RE: The University of Sydney, Darlington Campus (SSD 8636)

Thank you for notifying Sydney Water of the development application listed above. We have reviewed the application and, based on the provided information, we are objecting to the proposed development as it does not comply with the Sydney Water's guidelines for building over or adjacent to stormwater assets.

Building over or adjacent to stormwater assets

THE UNIVERSITY OF SYDNEY ENGINEERING AND TECHNOLOGY PRECINCT (ETP) - STAGE 1	Drawing Title SITEWORKS AND STORMWATER DRAINAGE PLAN - SHEET 1
--	---

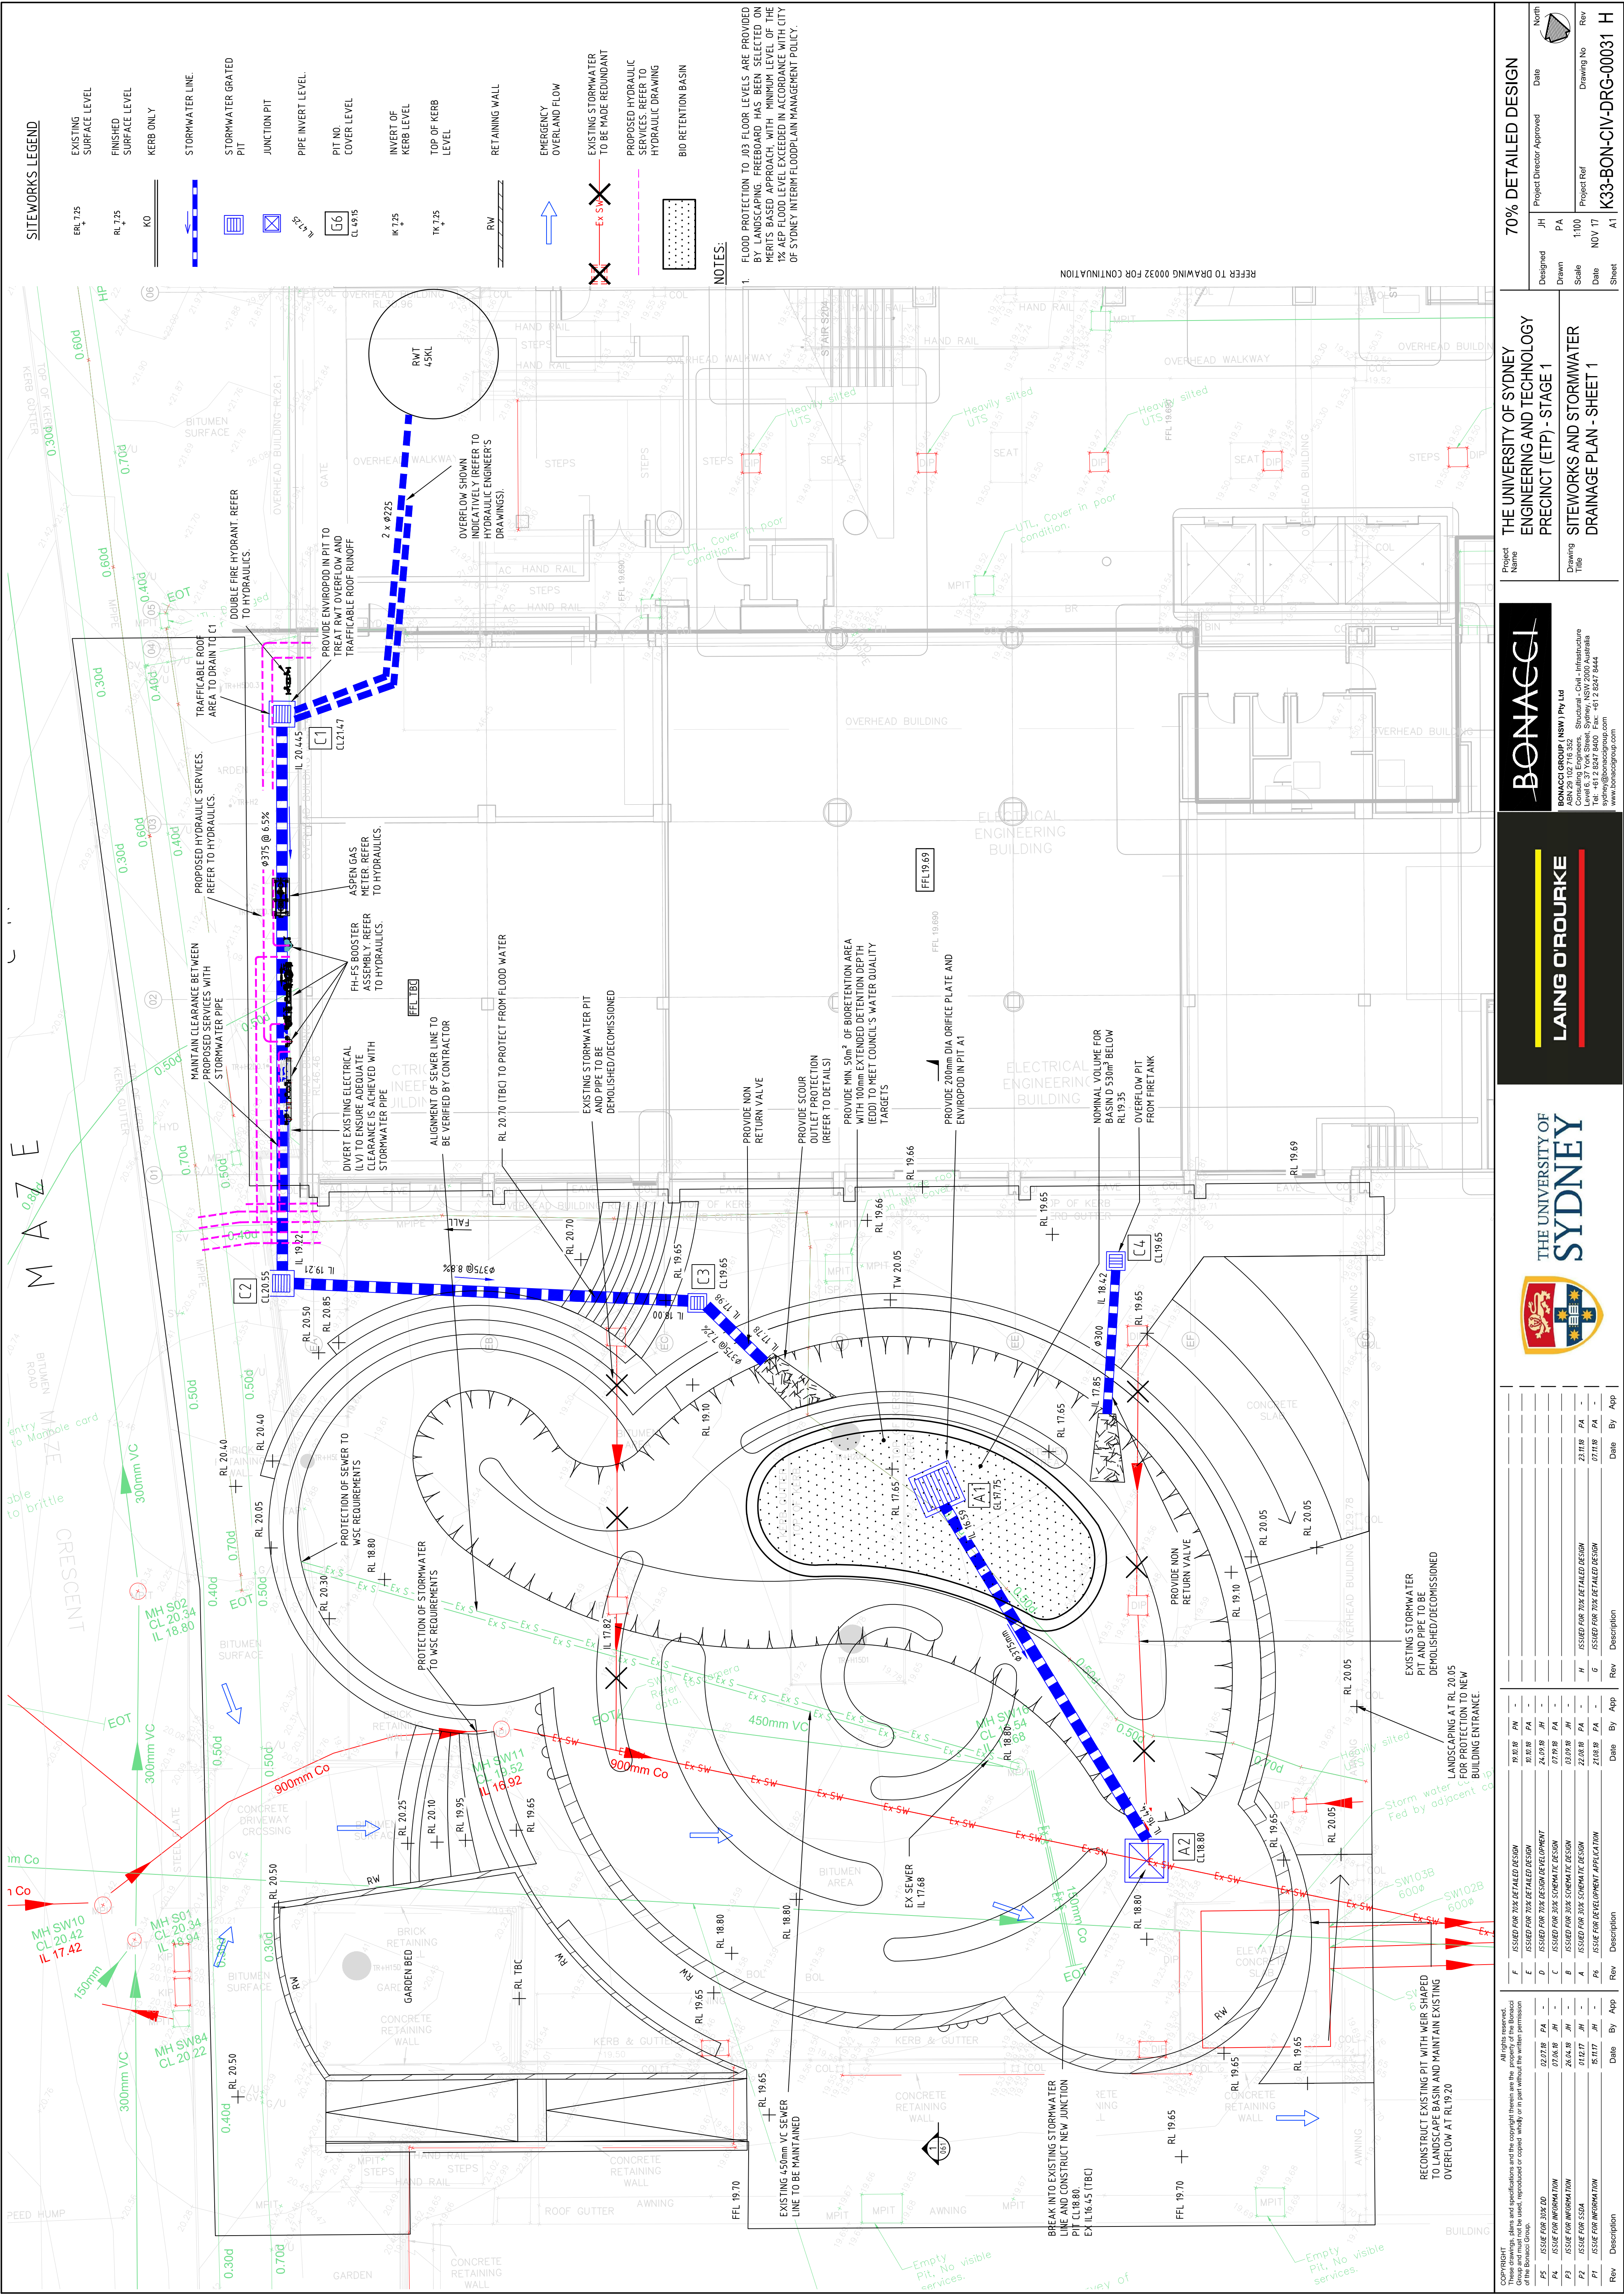
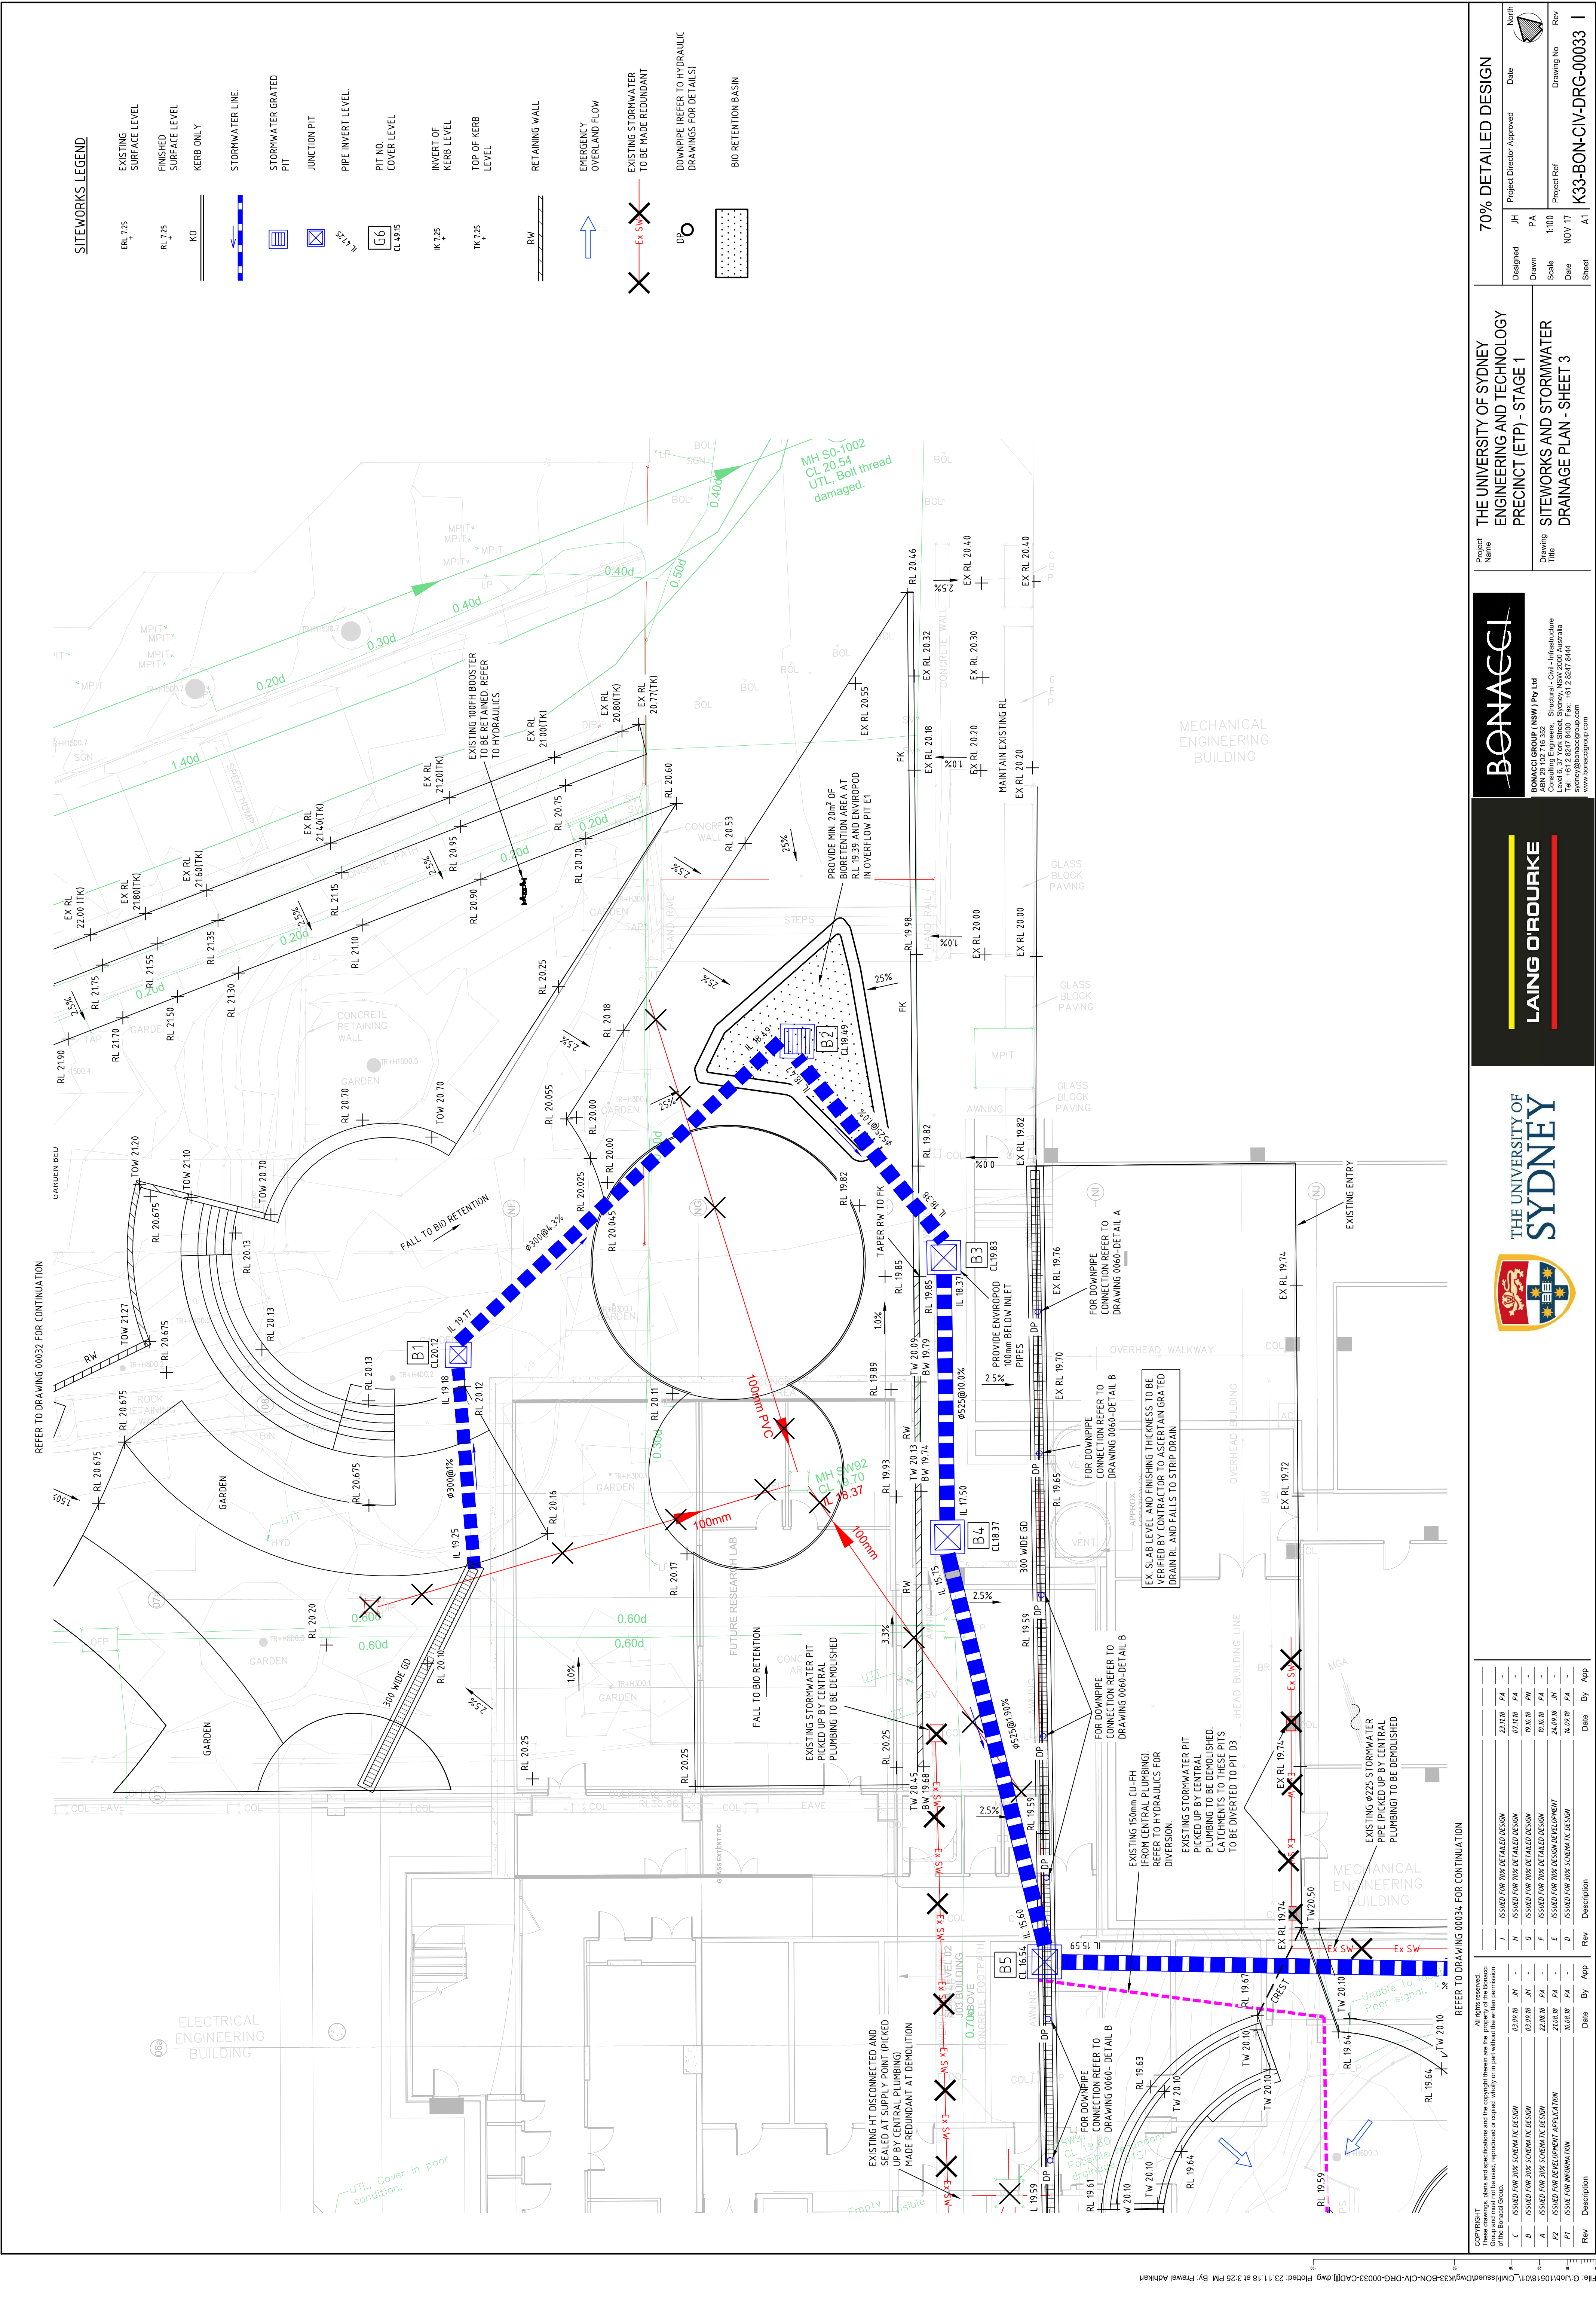
No building or permanent structure is to be proposed over the stormwater channel or within 1m from the outside wall of the stormwater asset. Permanent structures include (but are not limited to) basement car park, hanging balcony, roof eaves, hanging stairs, stormwater pits, stormwater pipes, elevated driveway, basement access or similar structures. This clearance requirement would apply for unlimited depth and height.

The applicant is required to submit the elevation drawings with the stormwater channel, to ensure that the proposed buildings and permanent structures are 1m away from the outside face of the stormwater channel.

The proposed development is to be revised to ensure that there are no buildings or permanent structures proposed over the Sydney Water's stormwater channel or within 1m from the outside face of the stormwater channel.
